Consultation Response Pro forma

1	Application Number	DC/19/00596 Walnut Tree Cottage, Sherbourne Street, Edwardstone	
2	Date of Response	06/03/2019	
3	Responding Officer	Name:	Thomas Pinner
		Job Title:	Heritage and Design Officer
		Responding on behalf of...	Heritage Team
4	Summary and Recommendation (please delete those N/A) Note: This section must be completed before the response is sent. The recommendation should be based on the information submitted with the application.	<p>1. The Heritage Team considers that the proposal would cause</p> <ul style="list-style-type: none"> No harm to a designated heritage asset because the proposed extension and other works would not cause any further harm to the significance of the listed building, subject to conditions. 	
5	Discussion Please outline the reasons/rationale behind how you have formed the recommendation. Please refer to any guidance, policy or material considerations that have informed your recommendation.	<p>The application concerns the erection of a single-storey extension to Walnut Tree Cottage, a Grade II Listed C17-C18 timber-framed dwelling (listed as Juglans). The heritage concern relates to the impact of the development

PROPOSED SIDE ELEVATION 1/50 (A1)

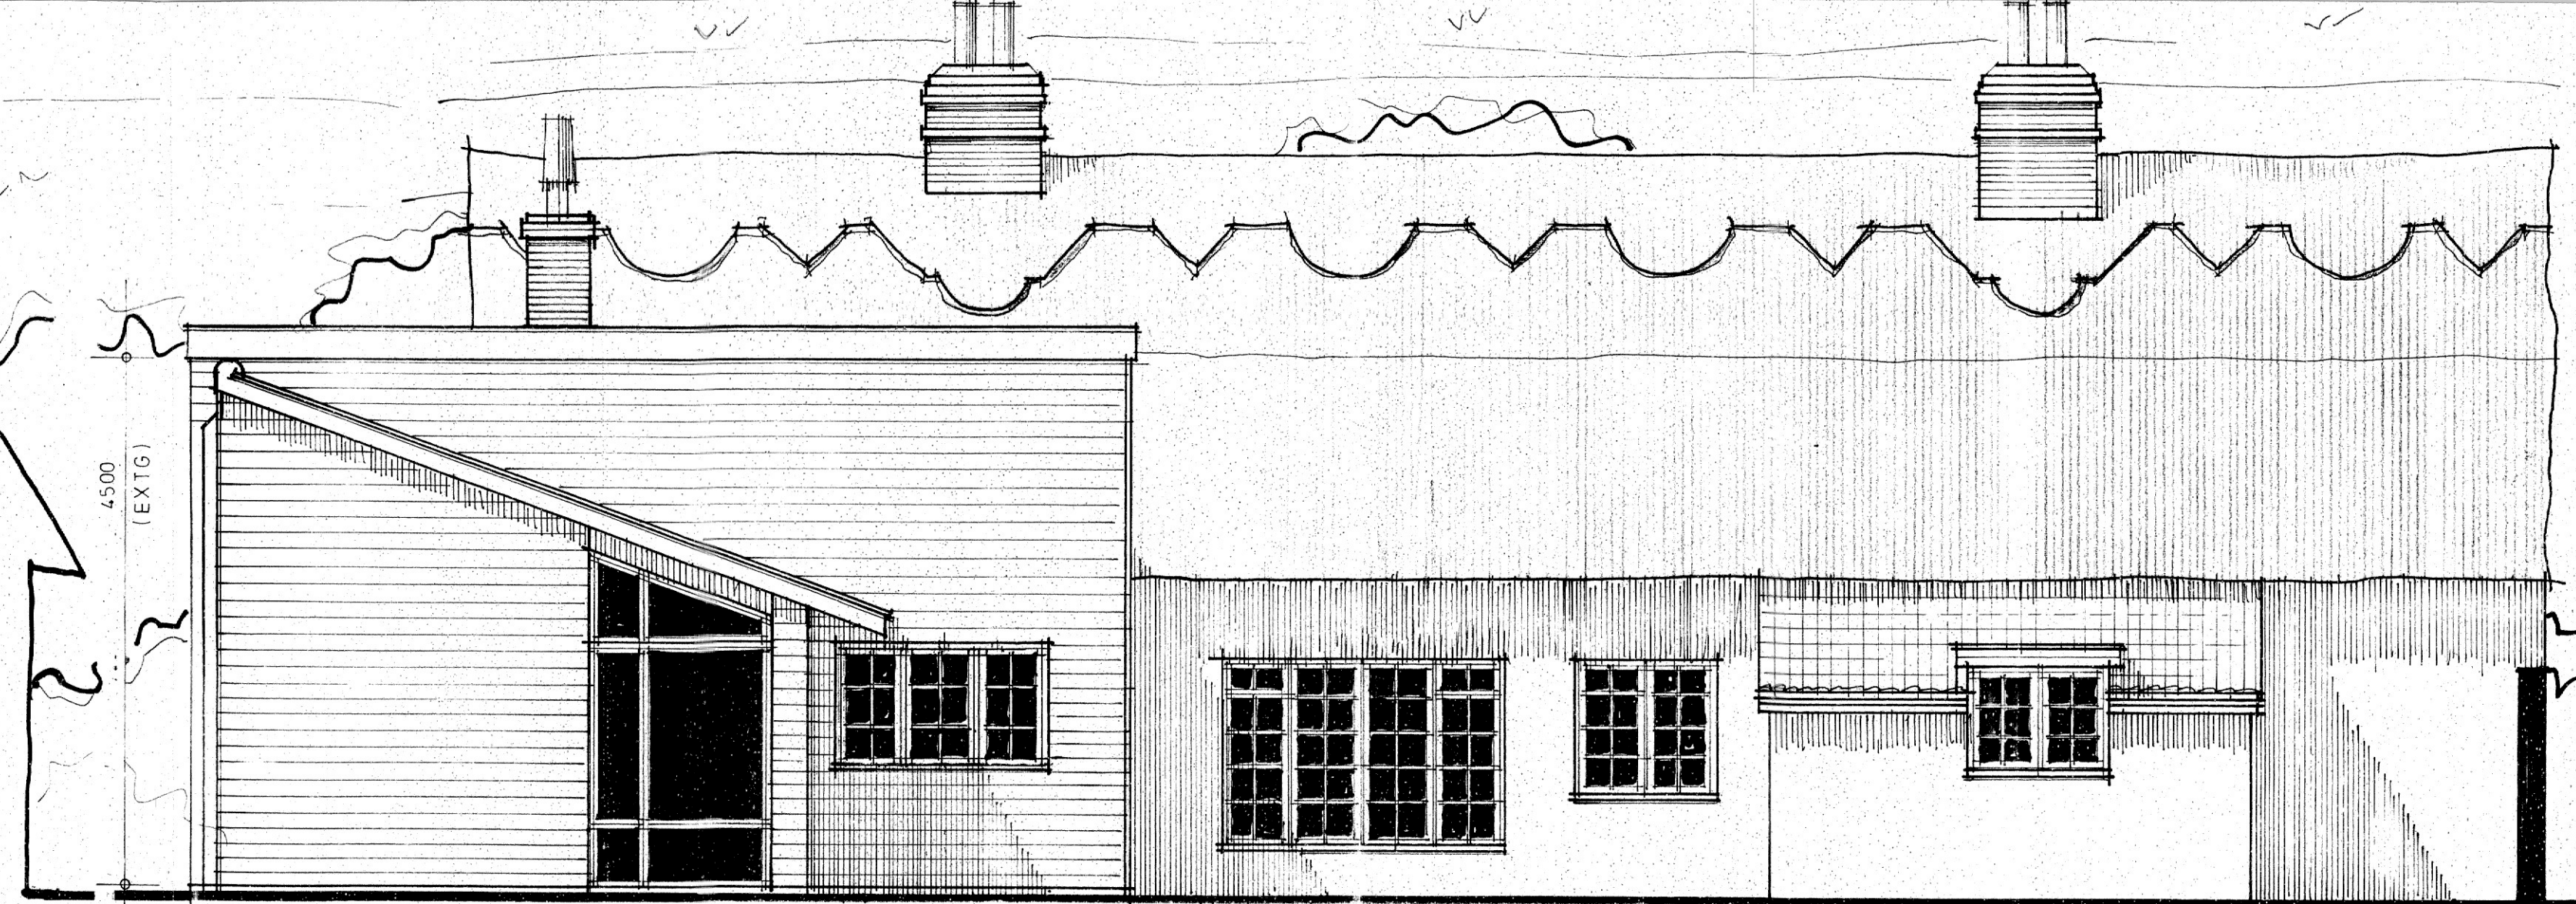
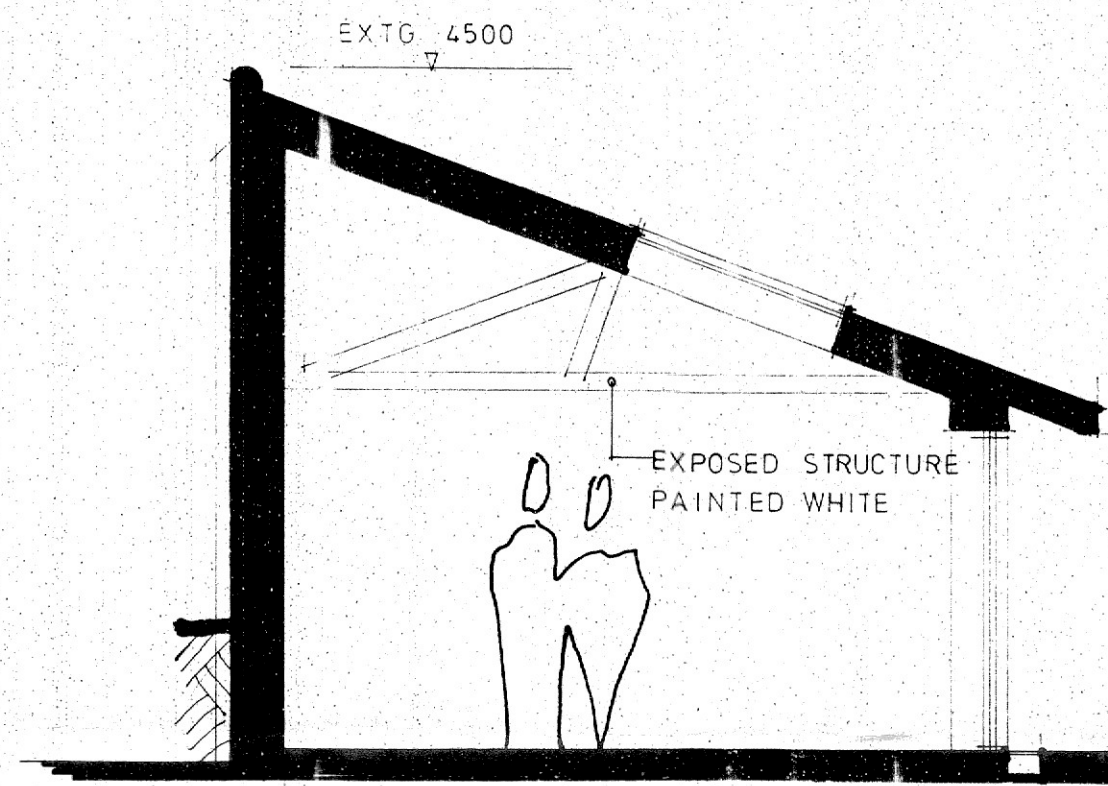
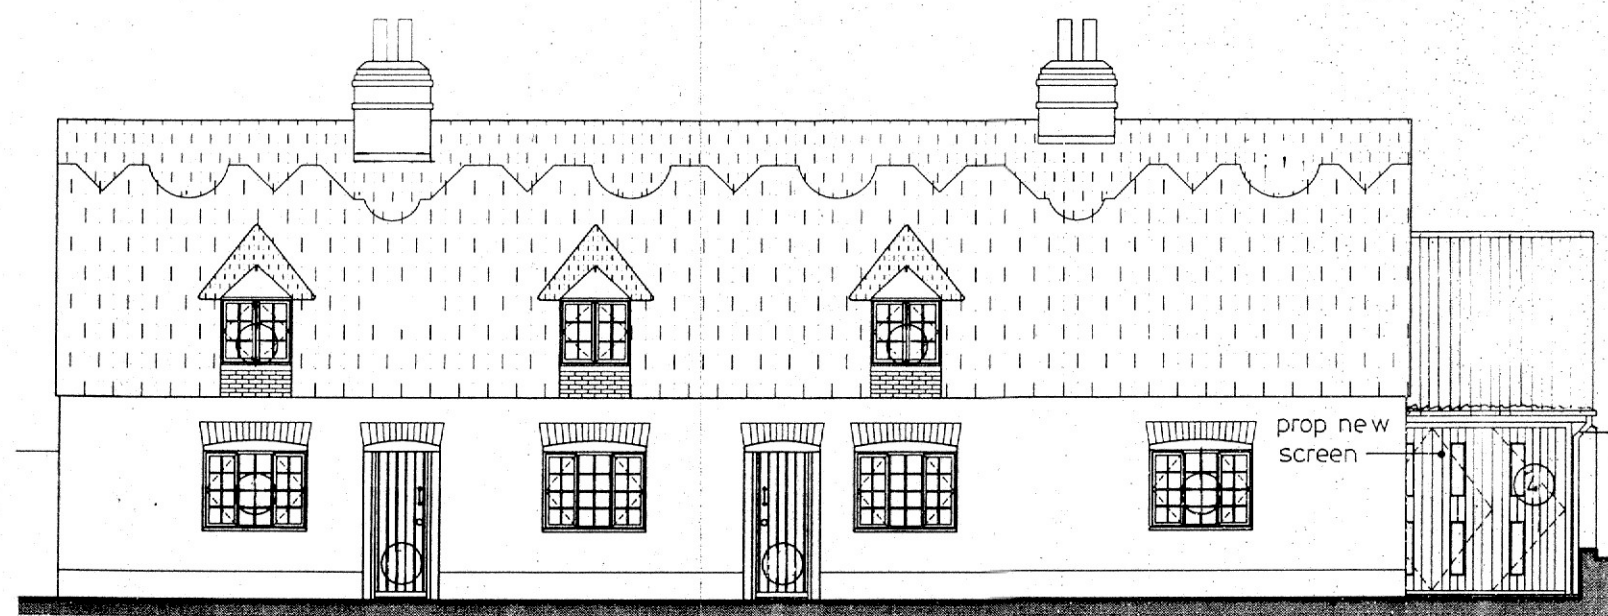
<p>The revised application proposes an extension of a similar footprint to the previous, but now proposes redesigning the mono-pitched roof form on the perpendicular wing, so that it incorporates the extension under a single, shallower mono-pitch, rather than introducing a new (flat) roof form. Consequently, the Heritage Team considers that the extension would not increase the complicated nature of the existing extension and therefore would not be any more harmful than the existing. Additionally, the increase in footprint of the extension is relatively minimal. The extension is therefore considered acceptable, subject to detail (see conditions).</p> <p>The proposed glazing on the extension would be of a more overtly contemporary form than the existing it would replace. This is considered to result in a slight improvement to the form of existing extension and thus make a minor enhancement to the significance of the listed building. It would reduce the disjointed relationship between the modern and traditional elements of the extension, subject to detail (see conditions).</p> <p>The Heritage Team considers that cladding the existing and proposed extensions with feather-edged weatherboarding is acceptable, as this would not harm the significance of the listed building.</p> <p>The Heritage Team considers that replacing the existing door/screen on the front (east) elevation of the 1970s extension is acceptable, as it is not of historic interest. Its proposed replacement is acceptable in principle, subject to detail (see conditions).</p> <p>The replacement of the large rear window on the rear elevation of the main building is acceptable in principle, as it is not of historic interest and the proposed window would not cause any additional harm in this case, subject to detail (see conditions).</p> <p>In conclusion, the application meets the requirements of s.16 of the P(LBCA)A 1990 and the policies in the NPPF and the Local Plan. It is for these reasons that the Heritage Team does not object to this proposal, subject to conditions.</p>

If concerns are raised, can they be overcome with changes? Please ensure any requests are proportionate	
7	Recommended conditions	<ul style="list-style-type: none"> - Manufacturer's details of all new roof facing materials. - Detailed elevation and section drawings of all new doors and windows, at 1:10 or 1:2 as appropriate. - Detailed section drawing through the eaves and verge of the altered mono-pitch at 1:10. - Any new rainwater goods to match existing.
